This submission is being made by H. Harold Secretary of the Castlefield Park Residents Association on behalf of the Castlefield Park Residents Association (address c/o 29 Castlefield Park, Clonsilla D15.).

The Castlefield Park Residents Association would like to make the following submission on the Railway Order that Irish Rail have submitted for the DARTWest project (Reference 314232).

MAY MDC STR LC04 DR C 0203 D

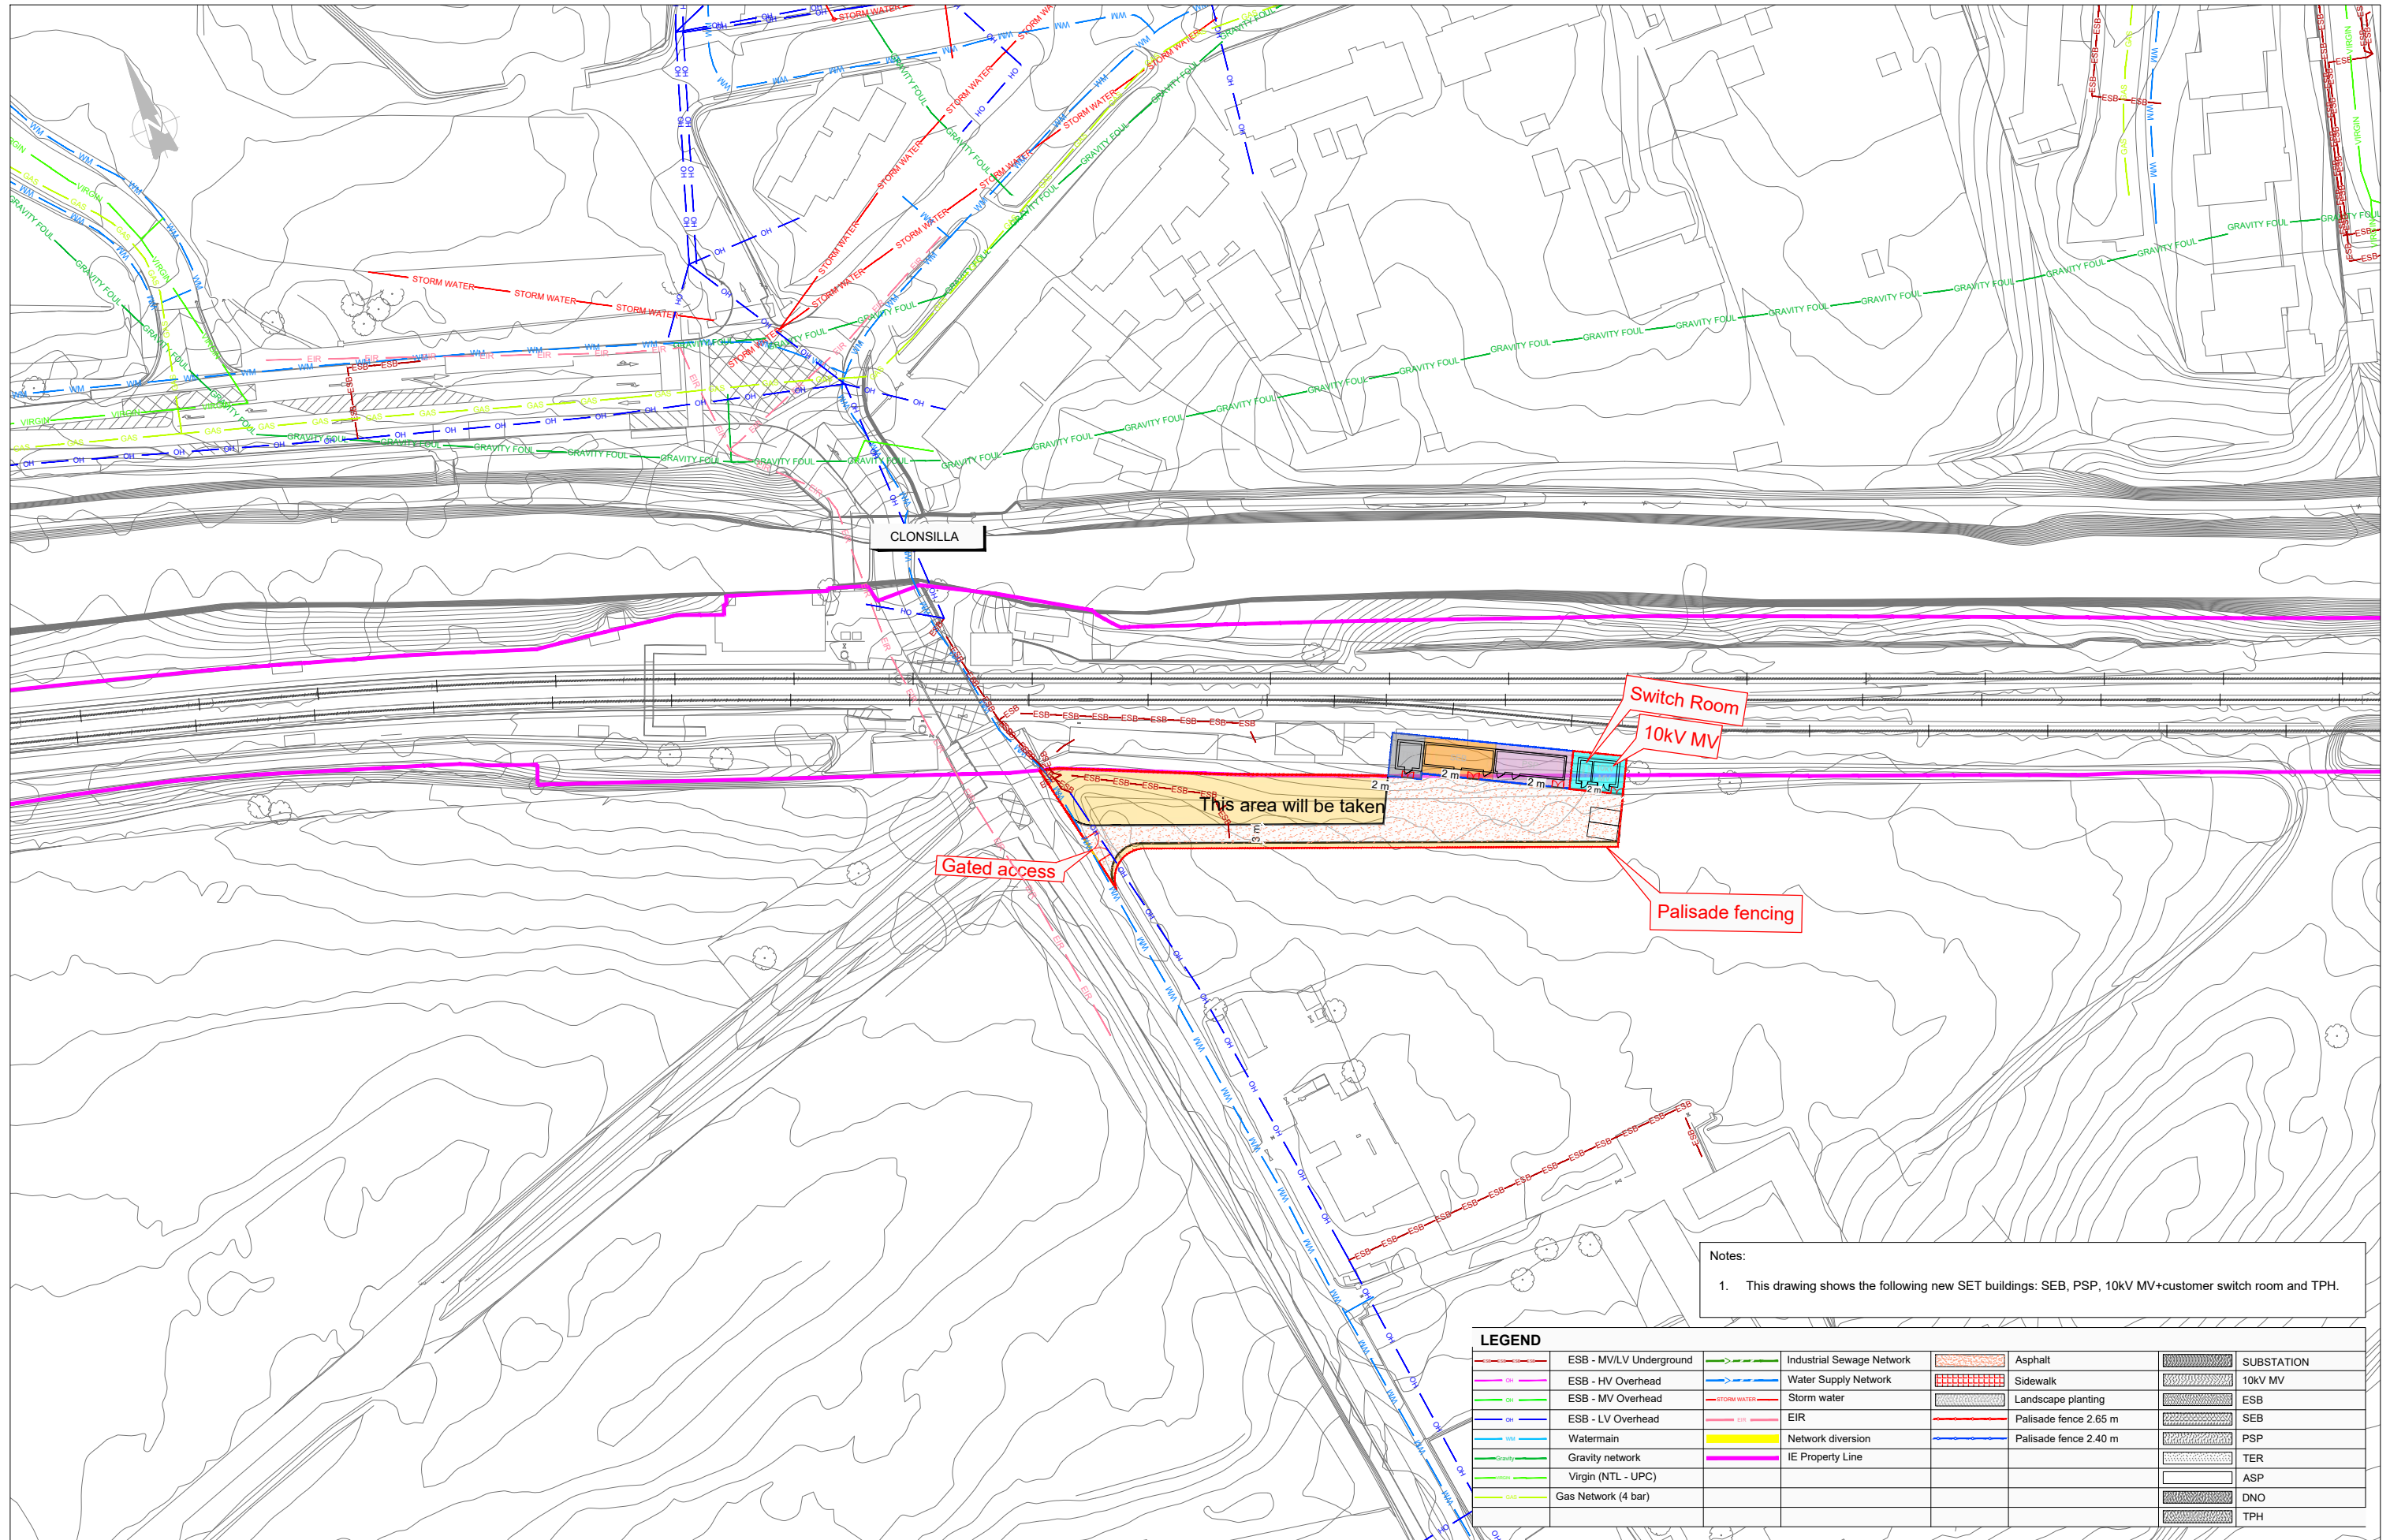
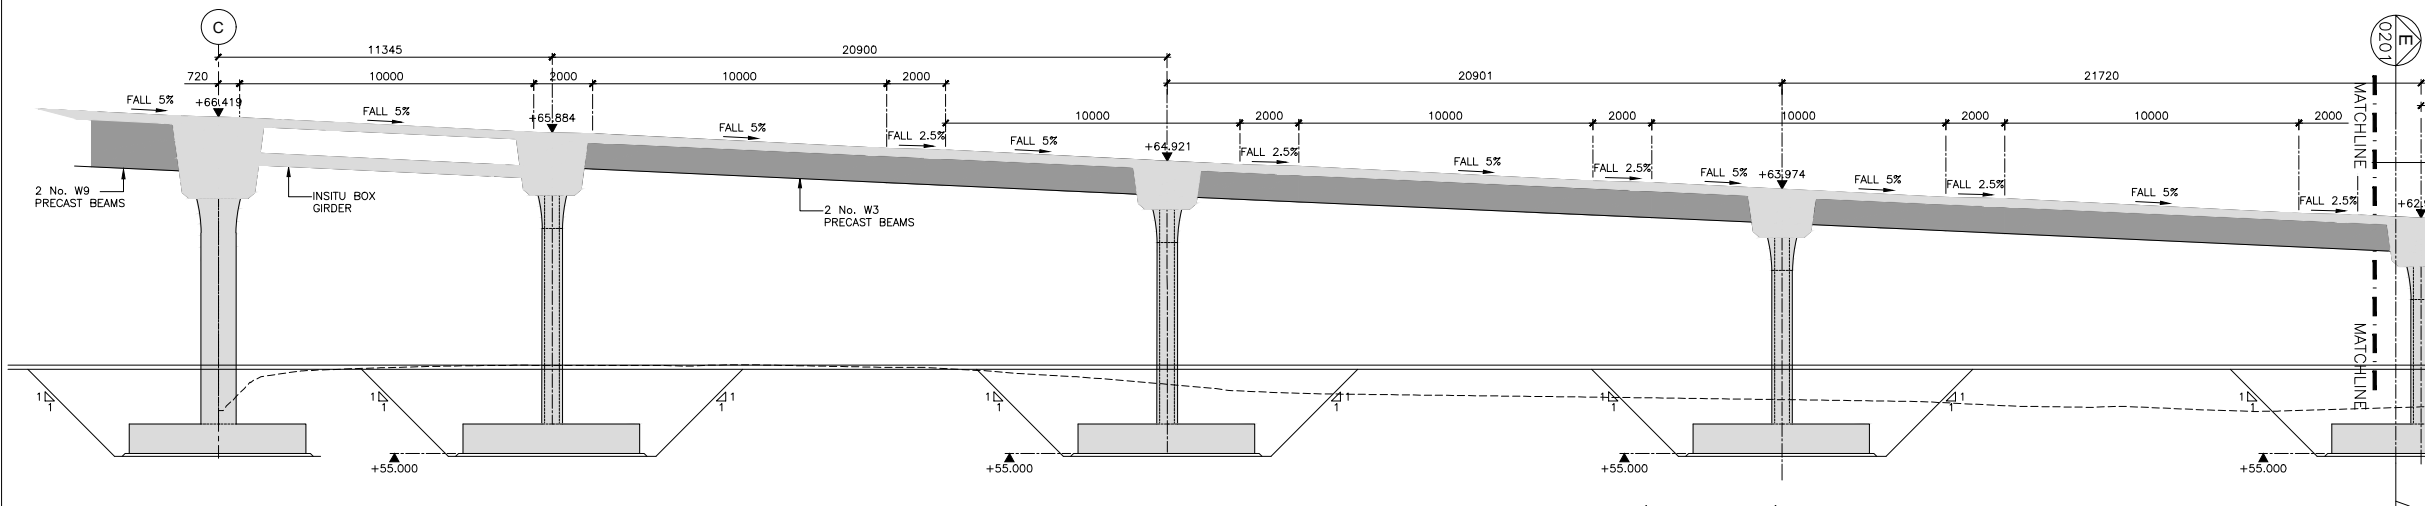
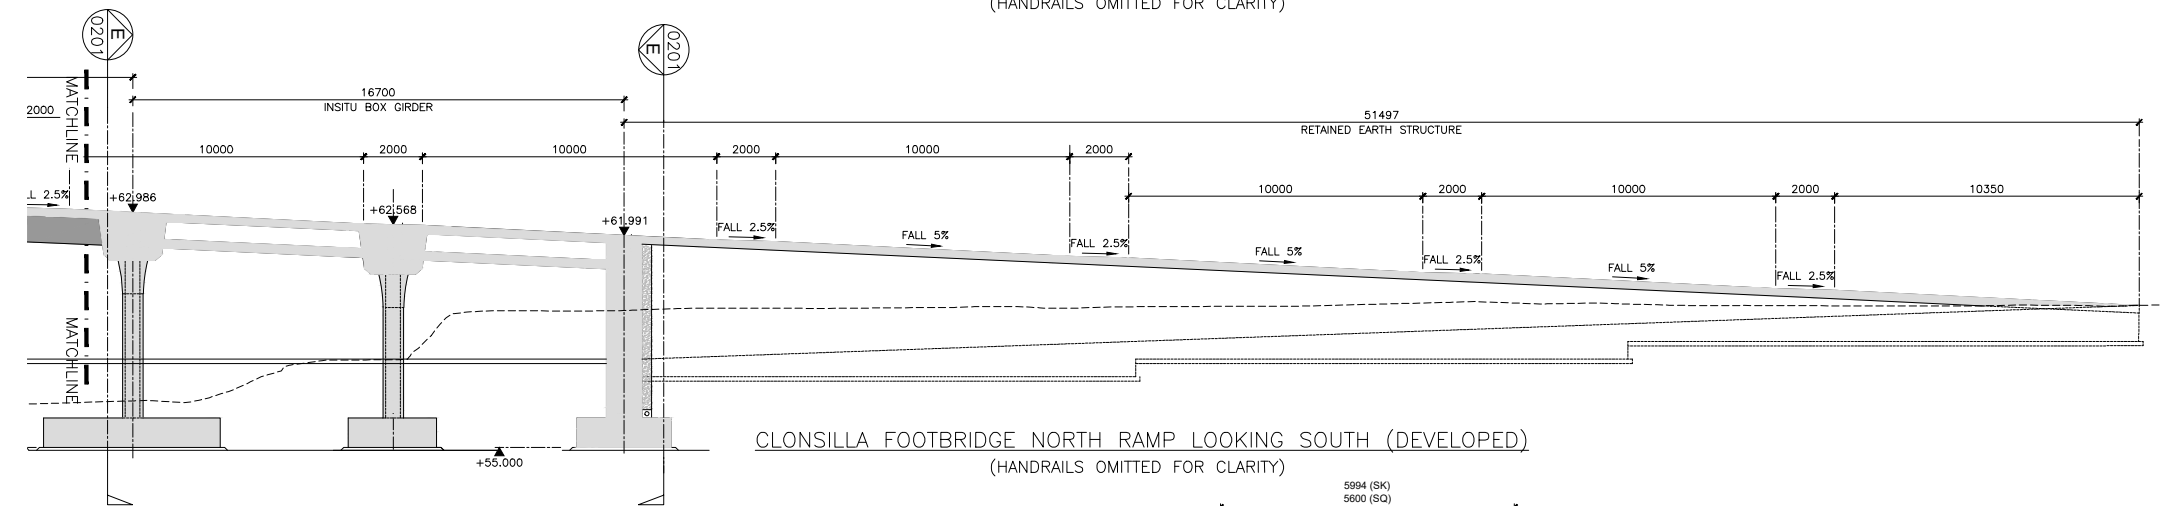
- The proposed access bridges at Clonsilla and Porterstown are unsightly and will dominate the view in these areas. This is of particular concern as both bridges are being built near historic elements that form part of the unique heritage and character of Clonsilla Village. The Porterstown bridge is beside the Old Schoolhouse which is a protected structure and the Clonsilla bridge is immediately adjacent to four protected structures; Callaghan Bridge, Clonsilla Signal Box, Clonsilla Overbridge and St Marys Church. There are more suitable locations for any bridge further to the west of these protected structures. The area around the Old Schoolhouse and the area around St Mary's Church are of key significance to the unique character and built heritage of Clonsilla.

- The proposed access bridges at Clonsilla and Porterstown are located at the site of the proposed Greenway and in a proposed Natural Heritage Area. The large size and unsightly nature of the bridges will impact negatively on the Greenway and the ecology and biodiversity of the proposed Natural Heritage Area.
